## Application by Photovolt Development Partners on behalf of Solar Five Limited (the Applicant) for an Order Granting Development Consent for the Botley West Solar Farm

**The Examining Authority's second written questions and requests for information (ExQ2): Issued on 30 July 2025**

- Order Limits
- Cable Corridor
- Cable Corridor Option

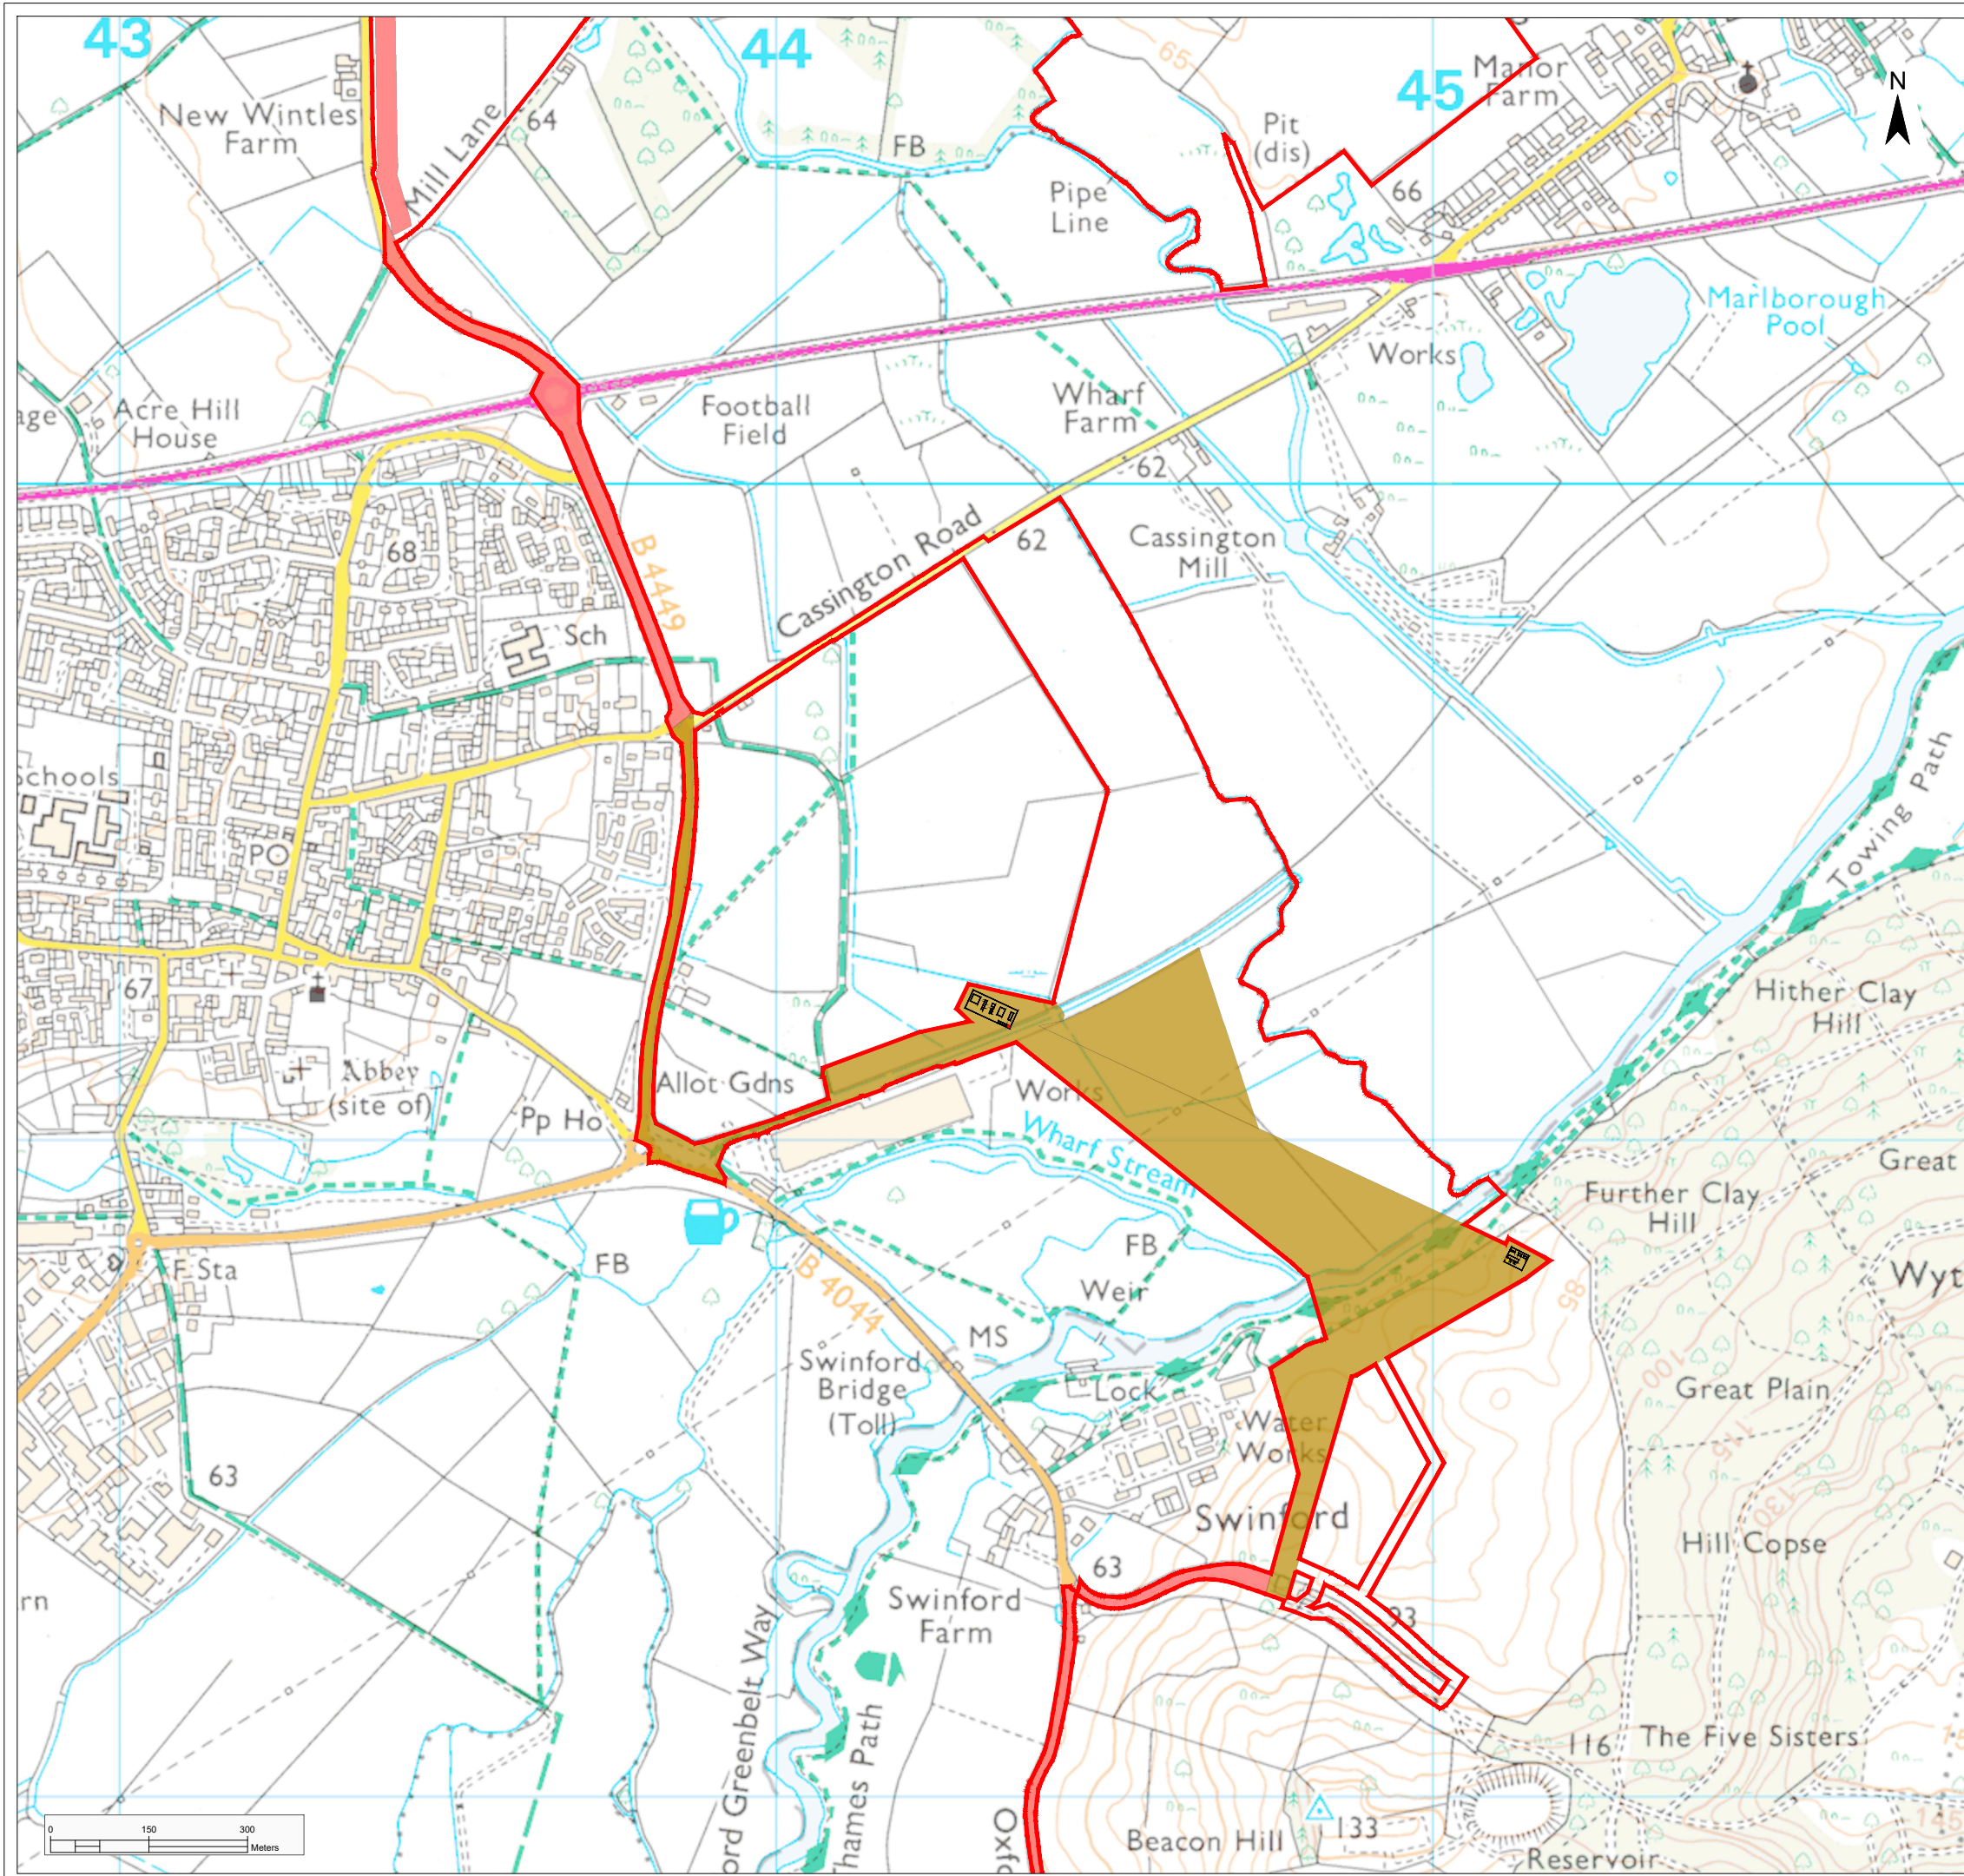
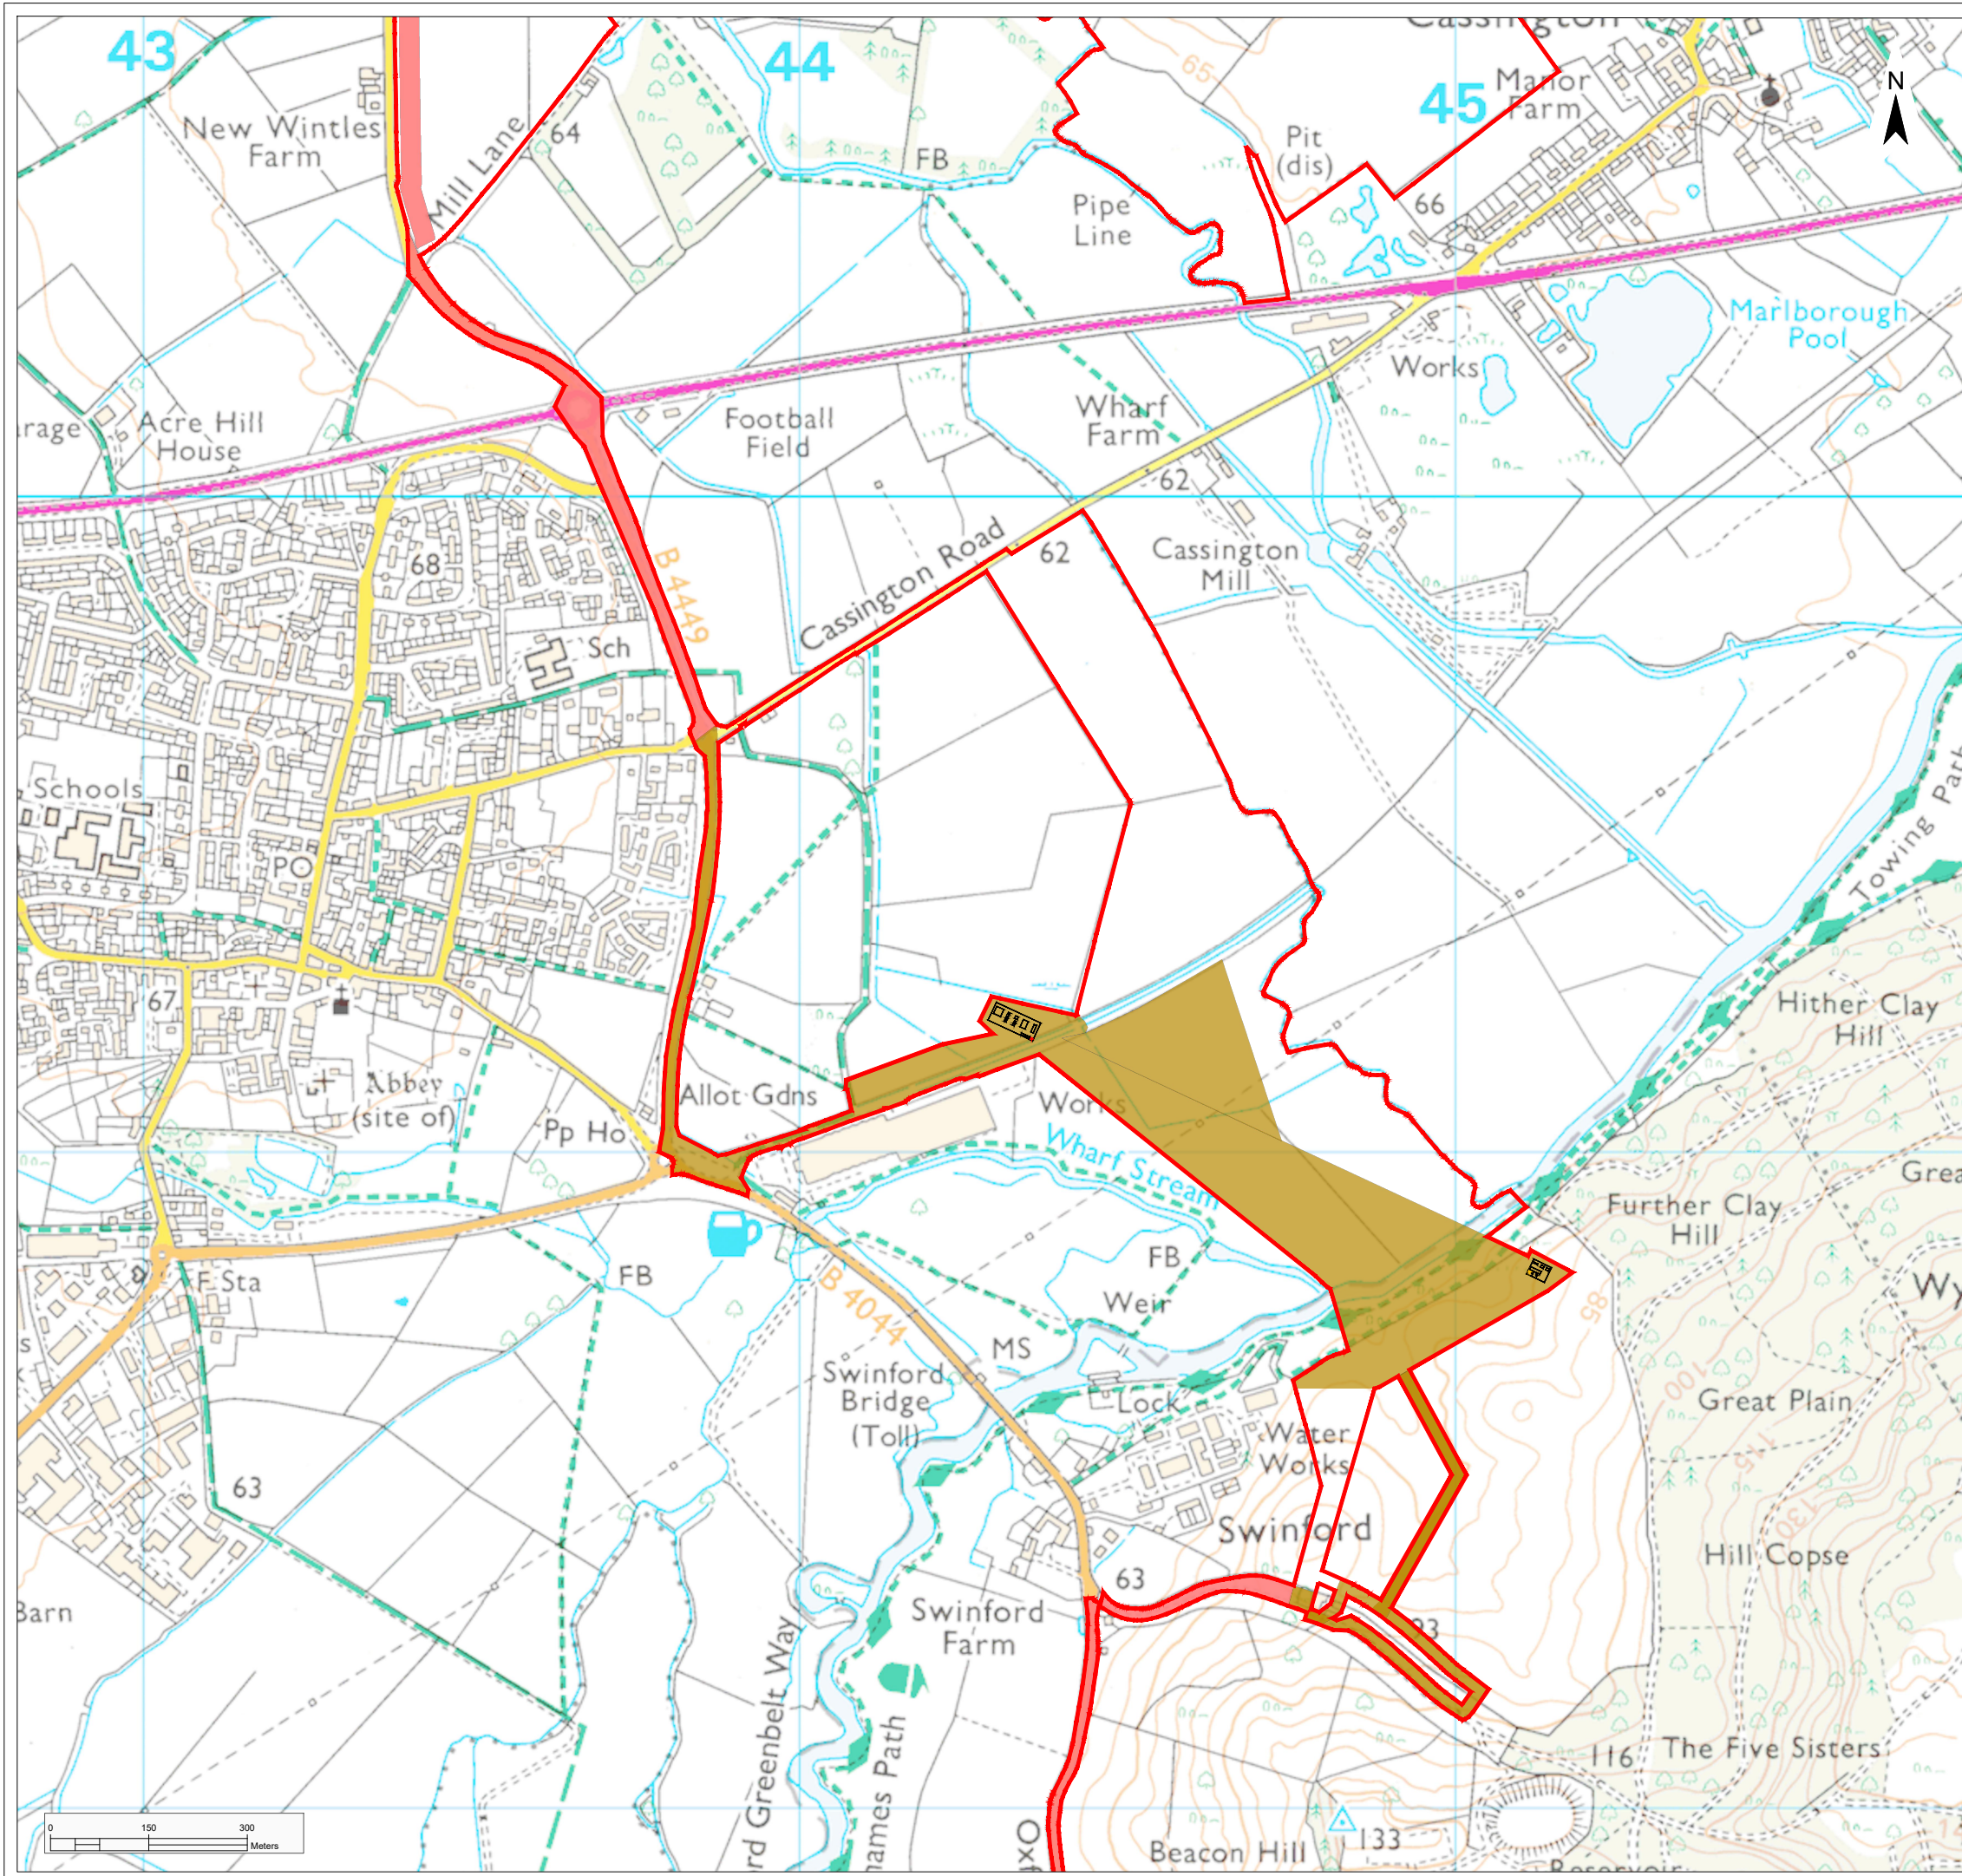
2.3.4	Applicant	<p><b>Cable corridor</b></p> <p>In response to ExQ1.3.10 [REP2-025], it is stated that any formal request to remove residual optionality (for the cable routing options) from the Order limits is unlikely until the outstanding surveys and agreements are concluded, which is expected in the post-consent phase. Explain:</p> <ol style="list-style-type: none"> <li>1) Who would be notified of the cable routeing decision outcomes and when.</li> <li>2) How would the discarded options be managed post-consent (i.e. for example is it just a case of not exercising Compulsory Acquisition powers)?</li> <li>3) Have any surveys or investigations to date indicated a potential preference in cable corridor routeing?</li> </ol> <p>Should the optionality, or at least the decisions in relation to the optionality, be subject of a Requirement that would secure a choice of cable routeing that subsequently prevents other options from also being pursued?</p>

2.3.8	Applicant	<p><b>Cable corridor</b></p> <p>In response to ExQ1.3.10 [REP2-025], it is stated that any formal request to remove residual optionality (for the cable routing options) from the Order limits is unlikely until the outstanding surveys and agreements are concluded, which is expected in the post-consent phase. Explain:</p> <ol style="list-style-type: none"> <li>1) Who would be notified of the cable routeing decision outcomes and when.</li> <li>2) How would the discarded options be managed post-consent (i.e. for example is it just a case of not exercising Compulsory Acquisition powers)?</li> <li>3) Have any surveys or investigations to date indicated a potential preference in cable corridor routeing?</li> </ol> <p>Should the optionality, or at least the decisions in relation to the optionality, be subject of a Requirement that would secure a choice of cable routeing that subsequently prevents other options from also being pursued?</p>
